STRATEGIC HOUSING UNIT
An Bord Pleanála
64 Marlborough Street
Dublin 1

Dáta | Date: 16/05/2022
Ár dTag | Our Ref: ABP 31328122
Bhur dTag | Your Ref. ABP-313281-22
Applicant: Cairn Homes Properties Limited

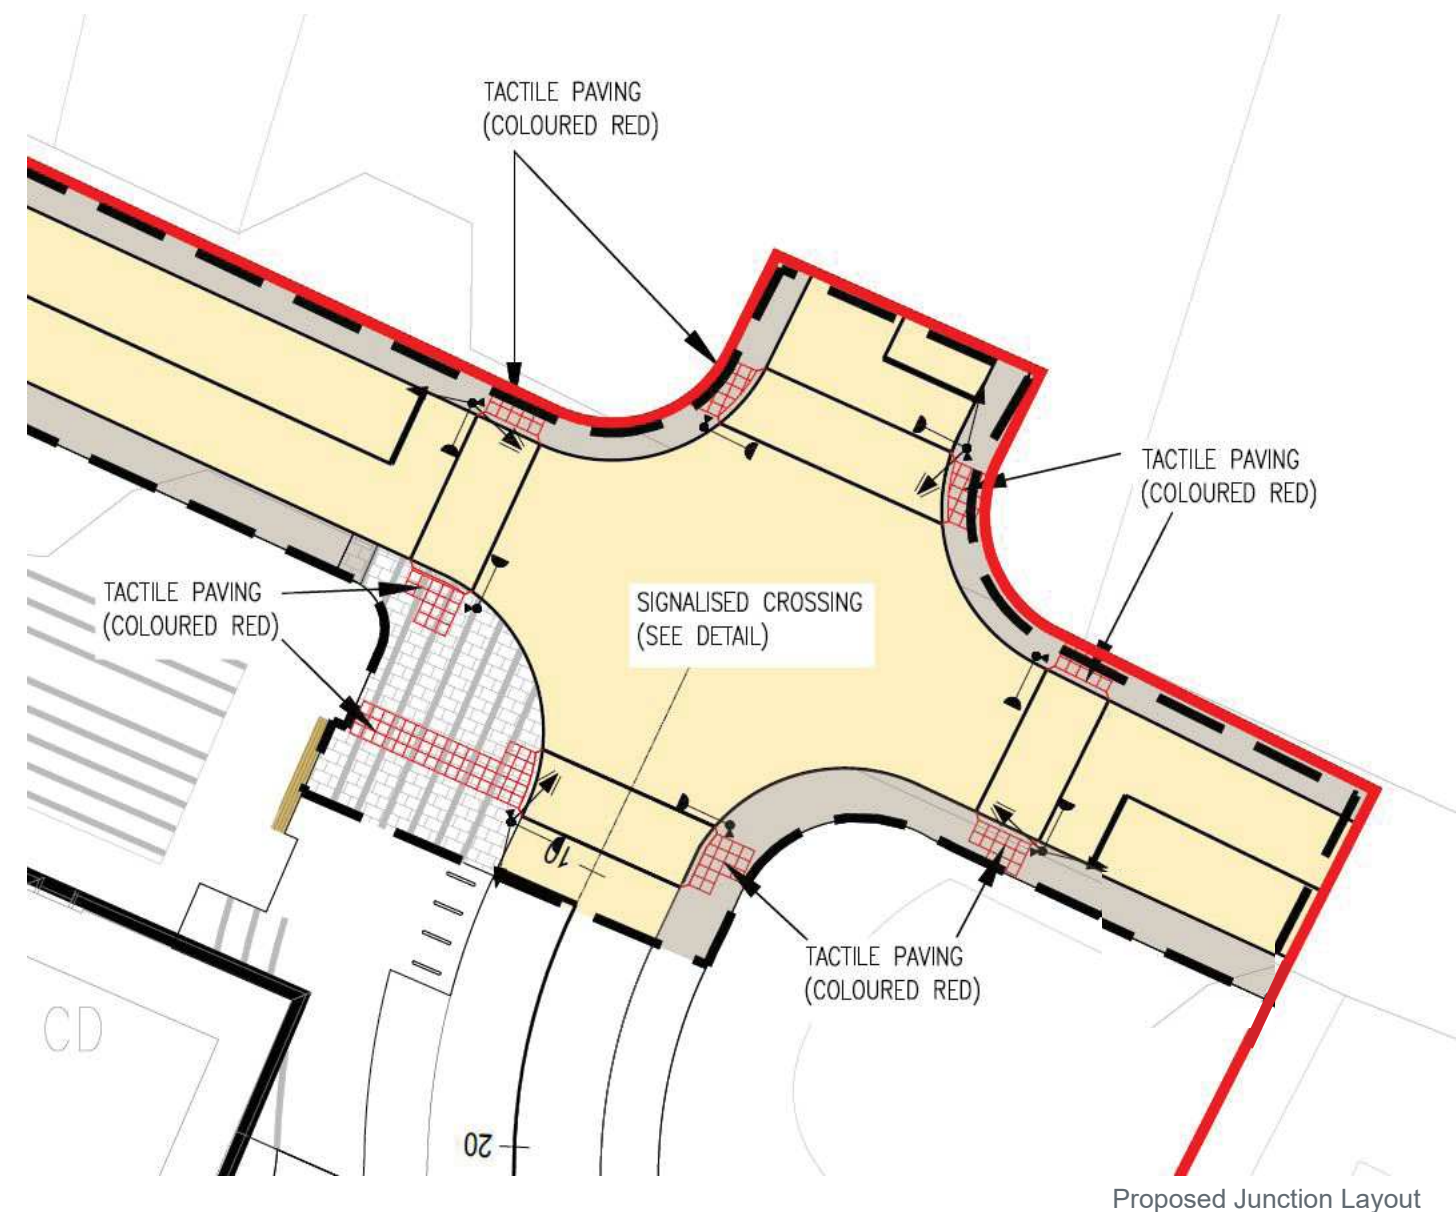
In the Authority's opinion, insufficient information in regard to the method of connection from the proposed site to Brennanstown Luas Stop is provided to demonstrate access for future passengers from the subject site. In addition, the Authority notes that the submitted site layout, landscaping and lighting plans do not appear to have specific regard to the presence of the Luas line and function of the southern end of the application site to provide safe and accessible access to Brennanstown Luas Stop in for example, the apparent absence of a pick up and drop off or turnabout for vehicles. This is a serious concern which needs to be addressed to promote sustainable and safe active travel in this area.
